From: Farhad Khatibi
Sent: 04 August 2023 12:42
To: Planning ContactCentre
Subject: RE: Attached letter from Kirklees Council regarding application number 2023/91272 at location Land Adj, 170, Penistone Road, Shelley, Huddersfield, HD8 8HZ

Please arrange for the inclusion of the following conditions for the above site:

**DWG TITLE** Plans, Elevations and Views

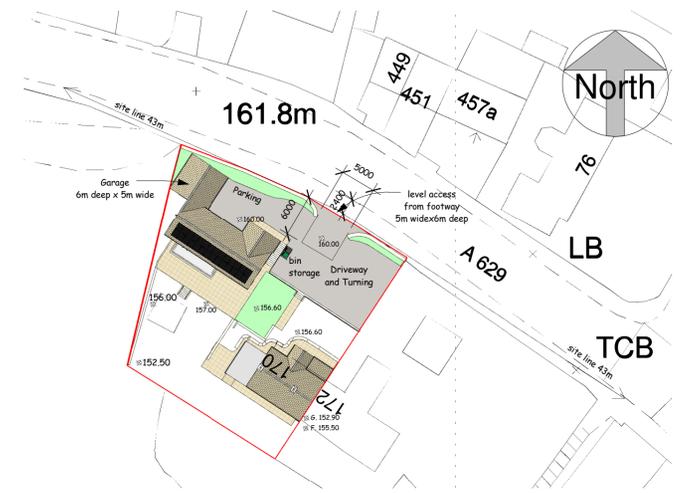
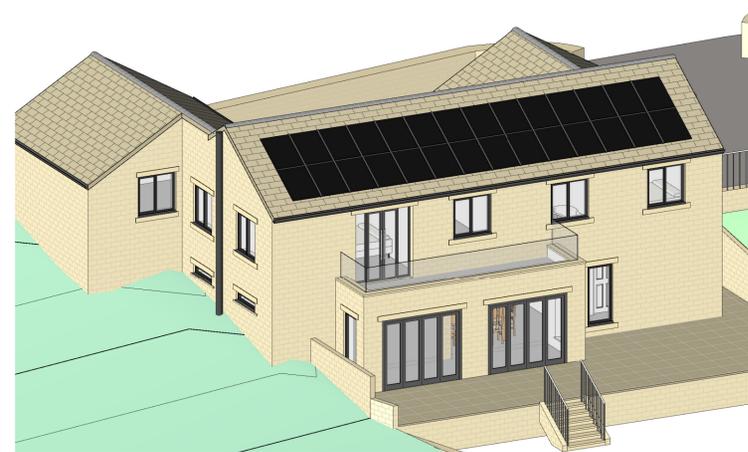
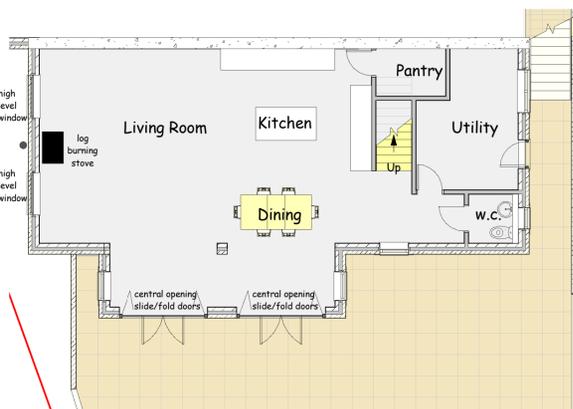
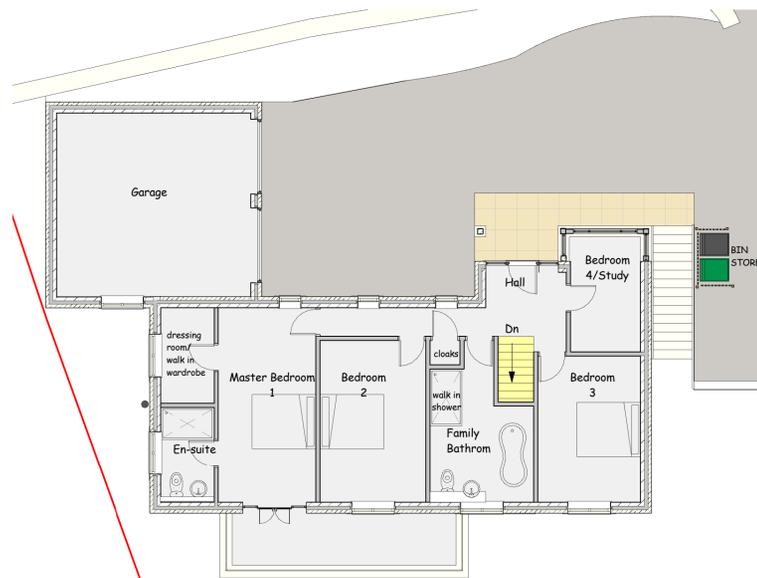
- 1) Before the development commences, the proposed partial demolition and modification to the existing highway retaining wall supporting A629 Penistone Road to form a new access together with the design and construction details for the new retaining walls around the driveway shall be submitted (via the submission of an AIP) and approved by the Highway Authority in writing. The approved scheme shall be implemented prior to the commencement of the proposed development and thereafter retained during the life of the development.

- 2) Before the development commences a scheme detailing the exact location and fully dimensioned cross-sectional information along with the proposed design and construction details for the new building/s adjacent to the existing highway retaining wall supporting A629 Penistone Road shall be submitted so as to determine whether the proposed works will be liable to a formal technical approval (via the submission of AIP) by the Highway Authority. The approved scheme shall be implemented prior to the commencement of the proposed development and thereafter retained during the life of the development.
